Recommendation Report for Planning Permission for Works or Extension to a Dwelling

REF NO: EP/123/15/HH

LOCATION: 102 Sea Road
East Preston

PROPOSAL: Side extension, dormer & front porch.

Scales:	No:
1:100 1:200	1799/01/02

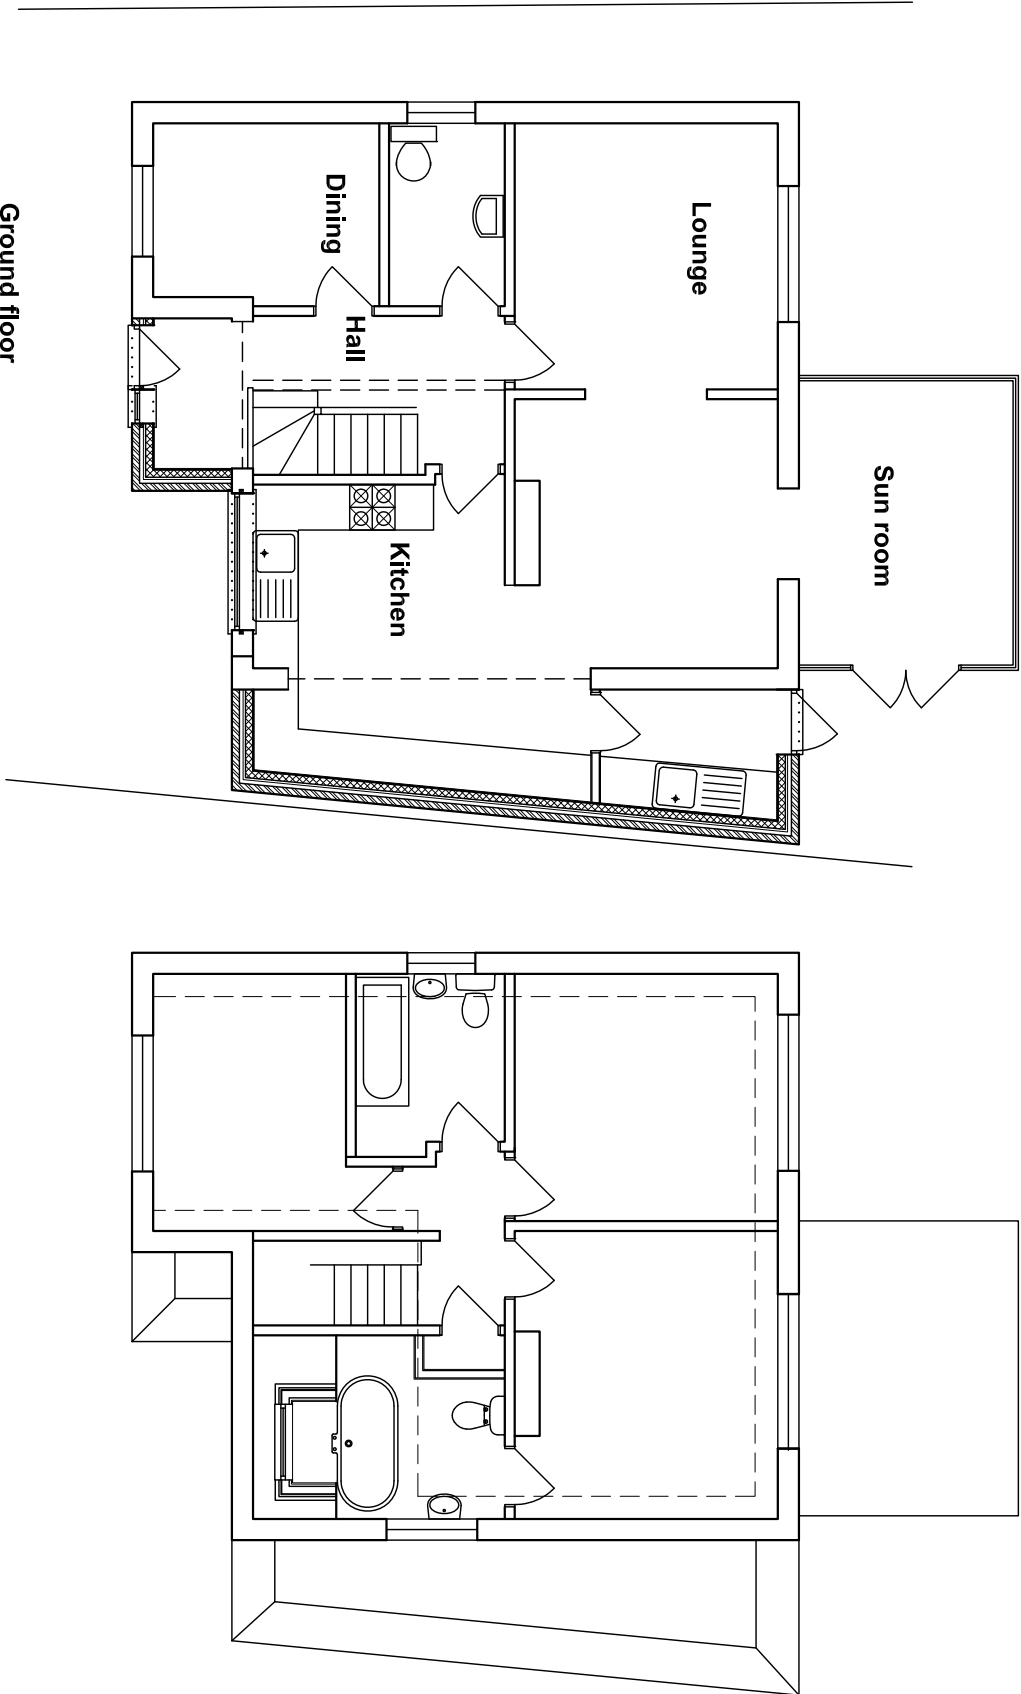
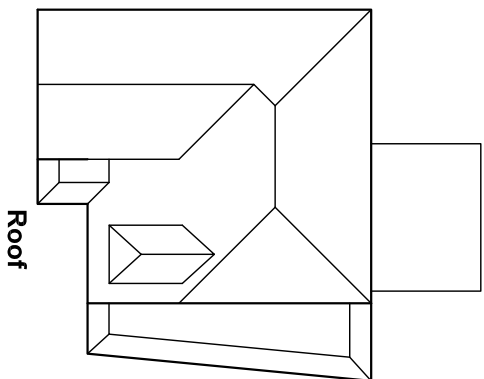
1. A single storey side extension along the full depth of the main north side wall of the dwelling. This would be 7.534m deep and vary between 1.329m in width at the front and 2.049m in width at the rear, due to the slightly irregular plot shape. No side windows are proposed. A rear door is proposed and the accommodation is an extended kitchen area and what appears to be a washroom/utility room. The side of the extension would be 0.15m away from the side boundary.

2. A single storey front extension which would be 2.283m in width and 1.32m in depth. This would be partly under a slight over sail in the existing front two-storey element. Outside of the area underneath the over sail the eaves would be 2.6m and the top of the roof plane would be 3.4m. Behind what will be a 'mock' pitch will be a flat roof which will not be visible.

3. A front dormer to an existing small room in the sloping roof. This will allow for provision of a second bathroom which would be accessible from the landing and would also be an en-suite to serve a bedroom. The dormer would have a hipped roof. The front wall of the dormer would extend 1.4m out from the roof plane. The roof would be hipped back. Dormer eaves would be 1.2m above roof plane and ridge 2.1m high.

This application seeks planning permission for the works described above and will result in a more limited change to the appearance of the existing dwelling. The extensions have been sympathetically designed in terms of endeavouring to match the appearance of the existing dwelling and are limited in scale. What is proposed will not result in a dwelling with a significantly increased massing and sits well within the site in terms of massing and scale and is not considered to be visually intrusive or detrimental to the appearance of the existing dwelling or the street scene.

The proposed development does not result in impacts on the residential amenity of surrounding occupiers in terms of privacy loss or dominance in outlook as the scale of development is limited and there is good separation between dwellings. In addition, no side windows are proposed. The new roof to the side extension slopes away from the adjoining dwelling.

- 3 No windows shall be constructed in the north side elevation of the extension hereby permitted which faces the side boundary with No.100 Sea Road without the prior planning permission of the Local Planning Authority to an application in that behalf.
